**Preferred Project Report
'Stage 2' Residential Development - Buildings 6, 9 & 10
61 Mobbs Lane, Epping (MP11_0048)**

Attachment 1

2 ROOF PLAN
1 : 100

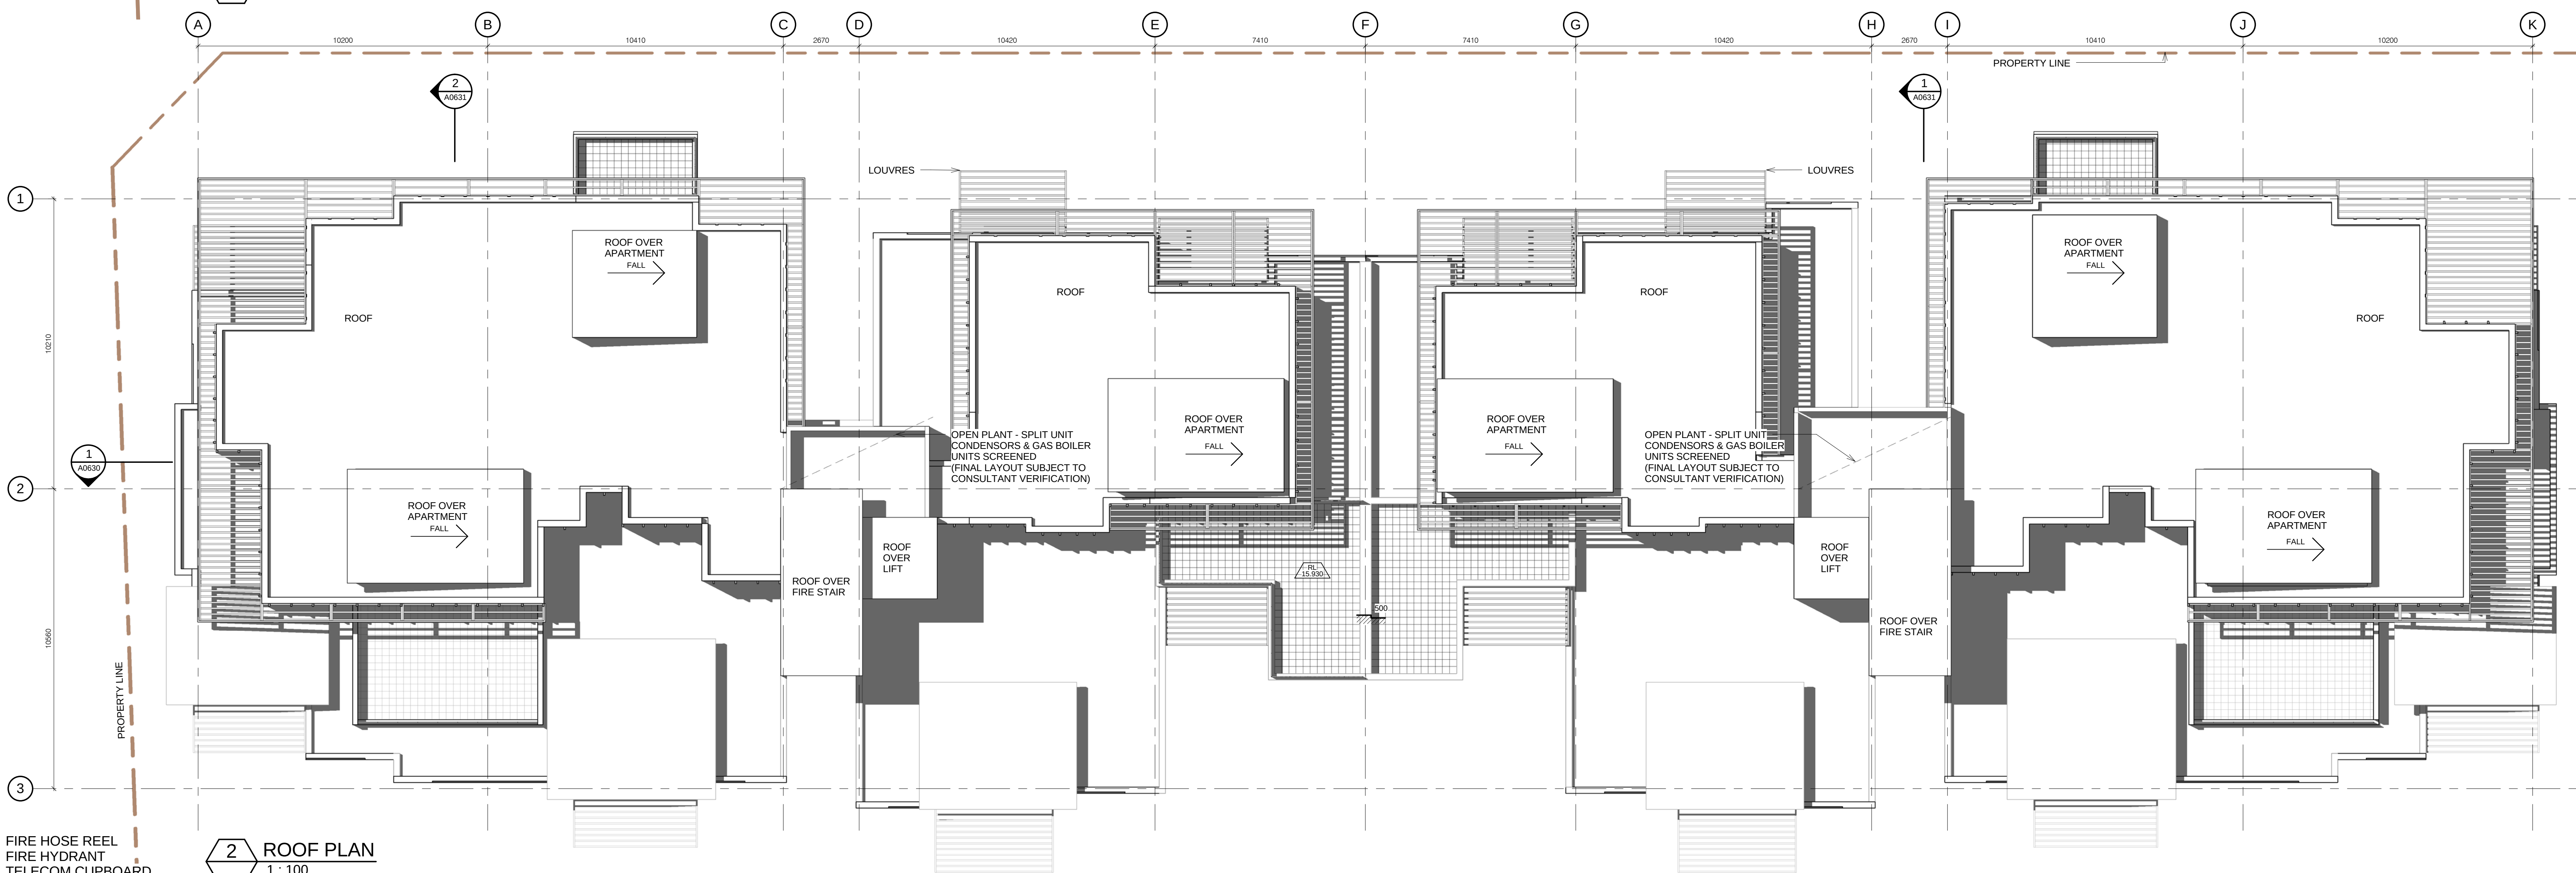
The concept approval prescribes a stepping down from a 6-storey element to the eastern elevation to a 5-storey element to the western elevation. The height of the fire stair roof also exceeds the 6 storey element. Roof design shall be reconsidered accordingly to ensure consistency with the concept approval.

2 NORTH-EAST ELEVATION - BUILDING 6

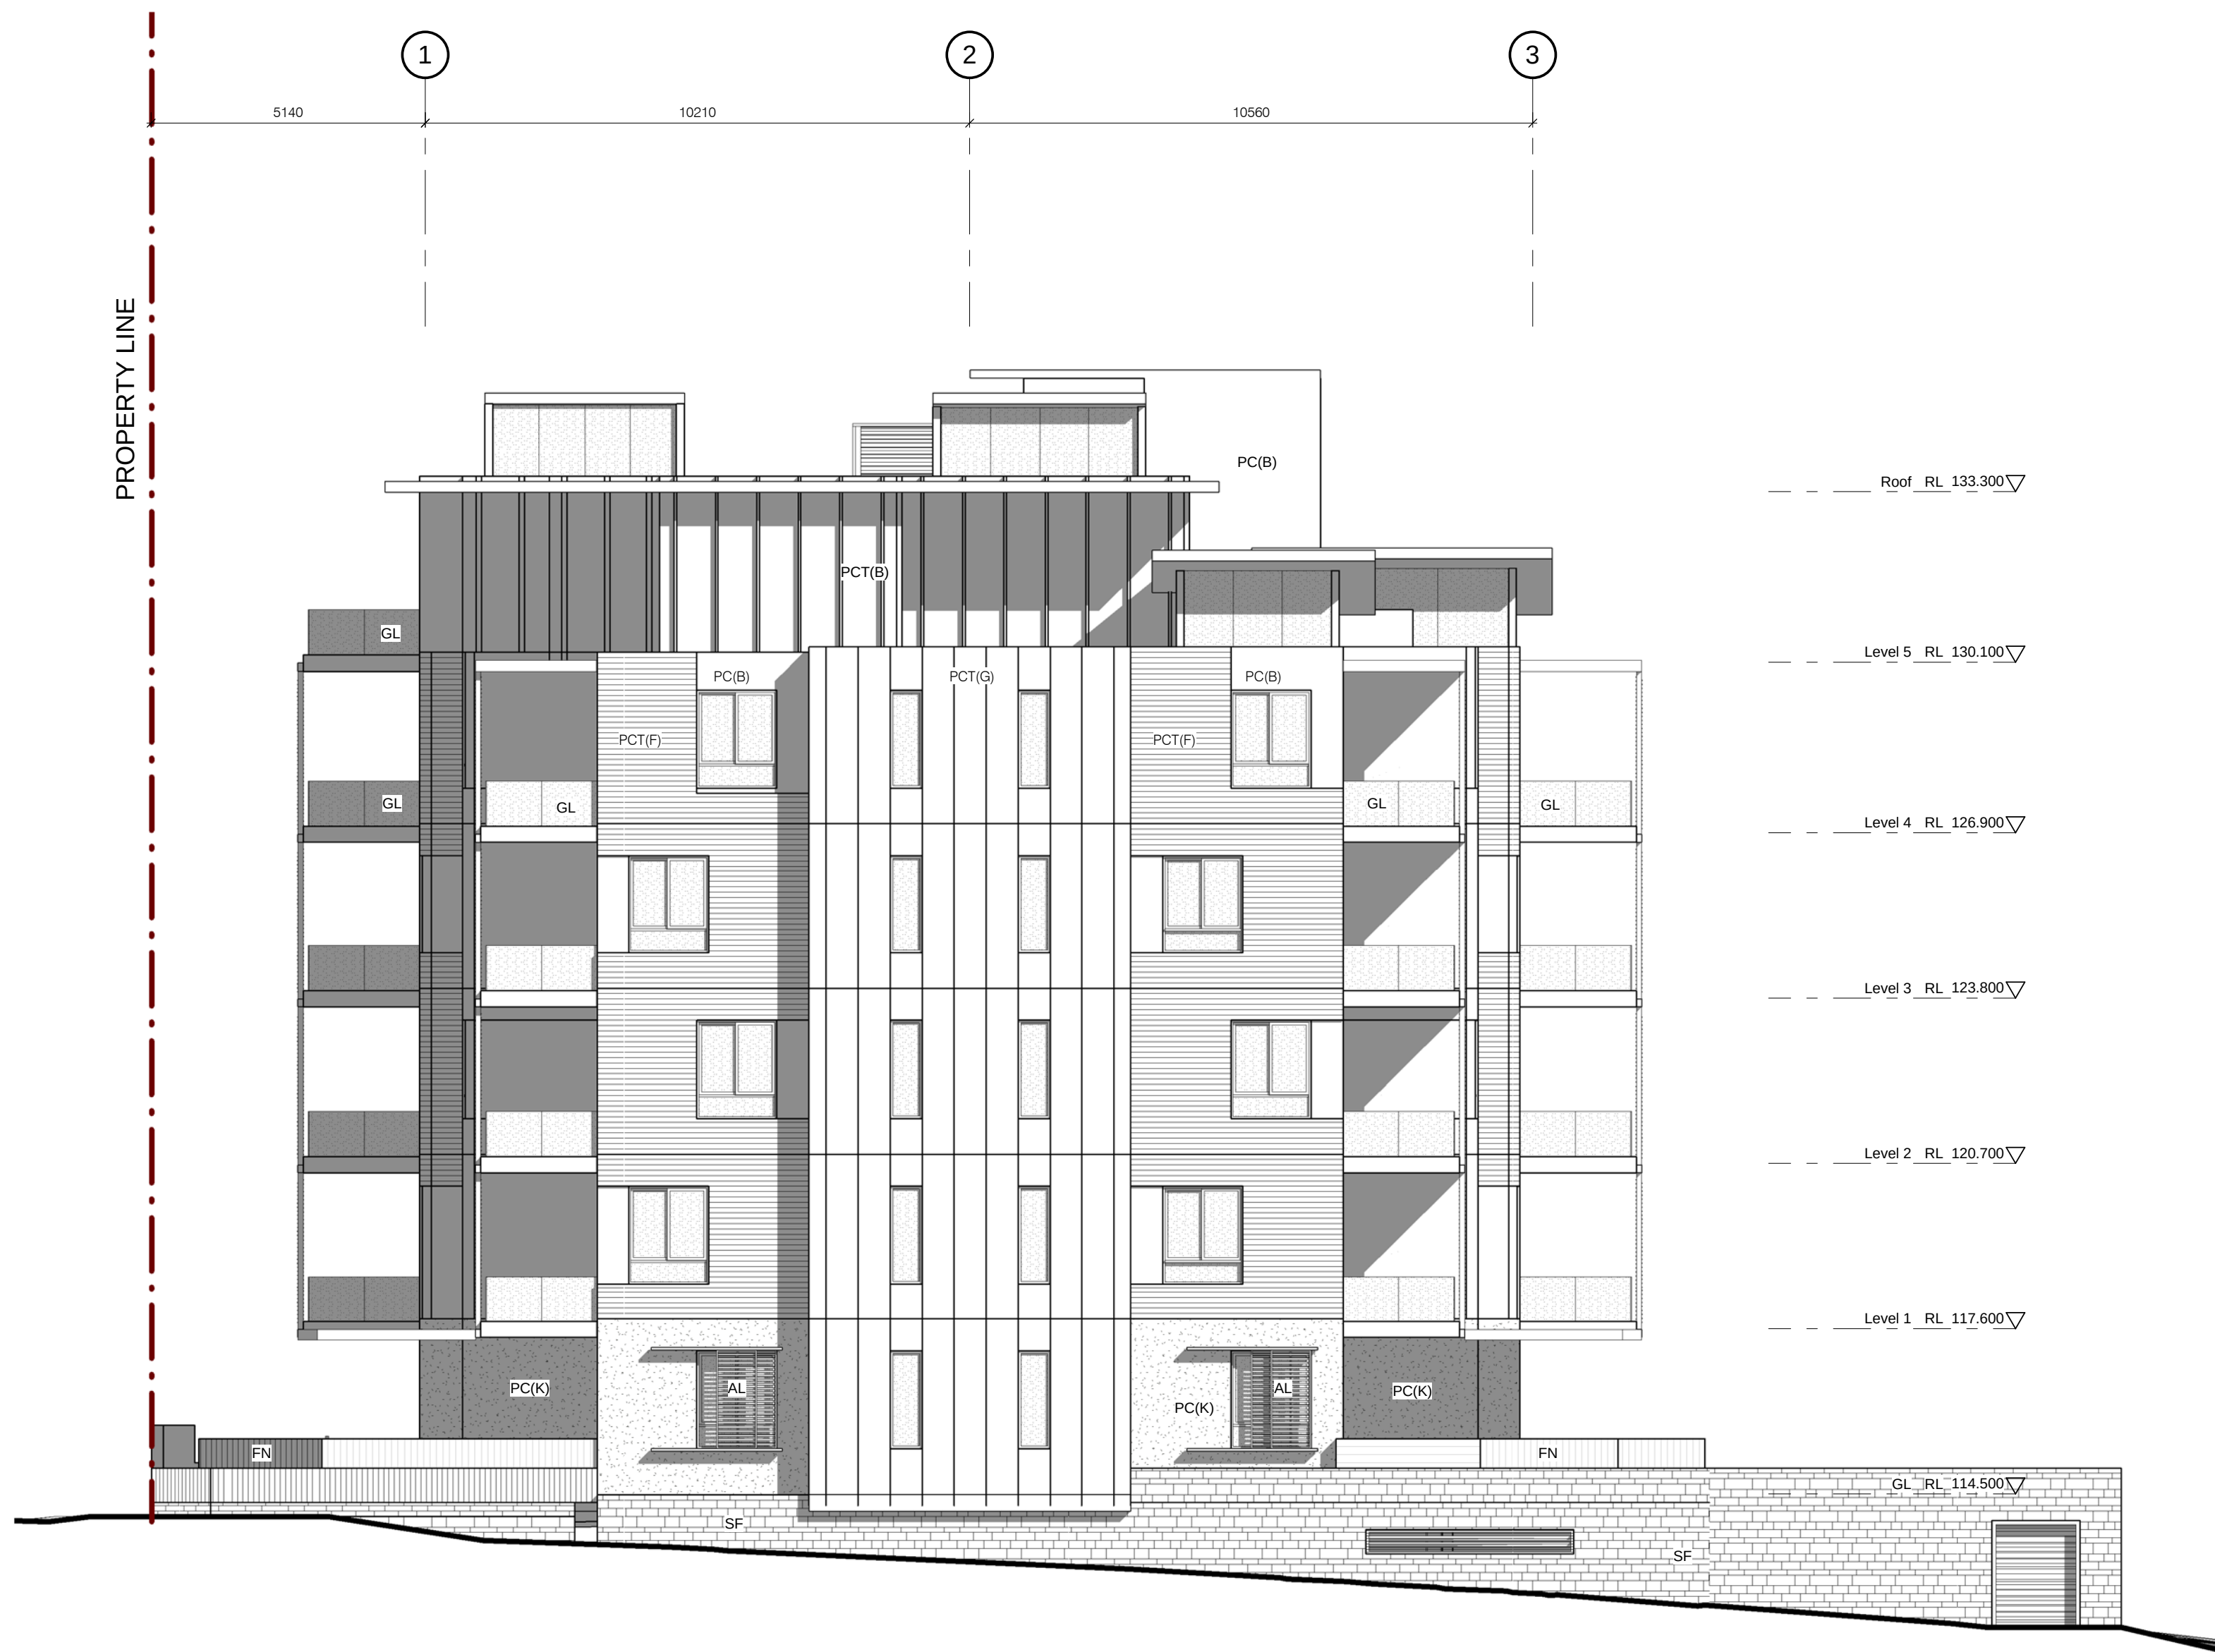
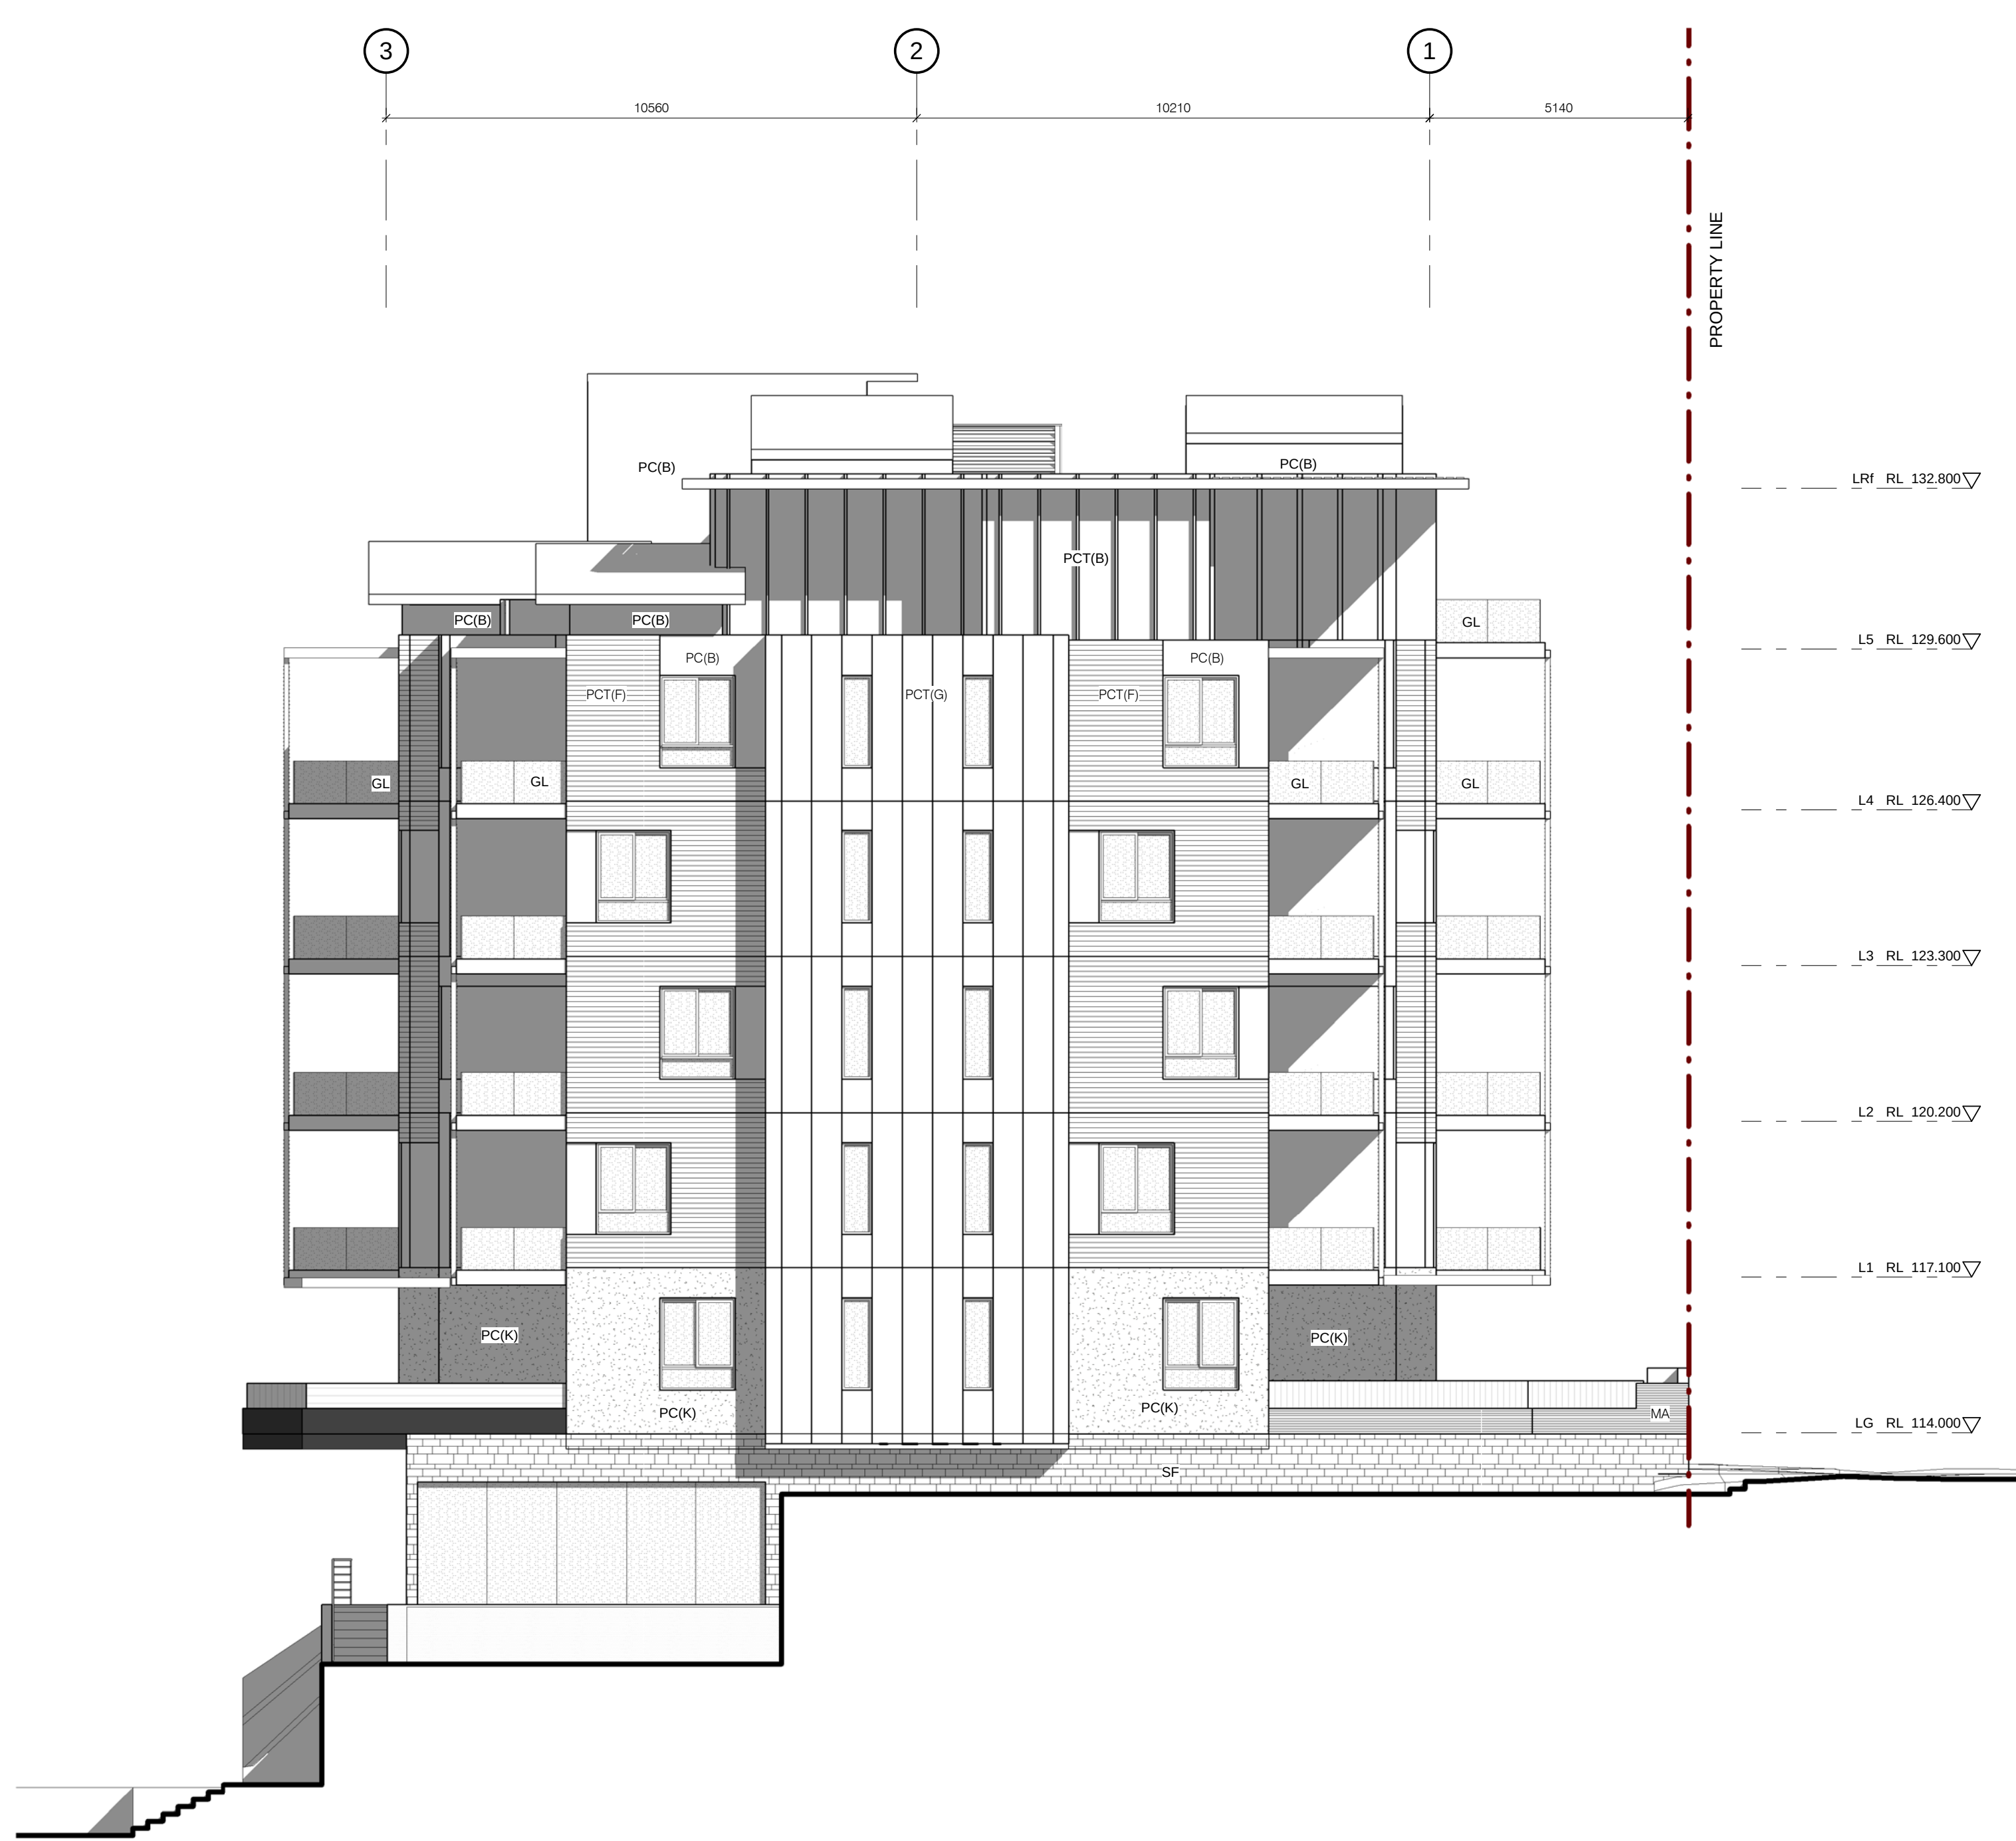
- the setback distances between Building 6 and Buildings 2 & 8 shall be illustrated in the elevation or separate section drawings
- the relationship between Building 6 and the tennis court/gym/retail complex shall be more clearly illustrated. Details of finished floor levels shall be included to indicate building height in context with the finished tennis court level

- the south-east elevation shall include ground level detail between Building 6 and Building 2 to illustrate the natural/future ground level at pedestrian level
- plans shall more clearly illustrate elevational treatment at pedestrian level at the south-west corner of the building
- further annotation in drawings A0612 and A0621 is requested for the retaining wall/landscaped area between Building 6 and the tennis court. Further detail is required for the car park entrance and driveway
- shadow diagrams shall be amended to include the tennis court
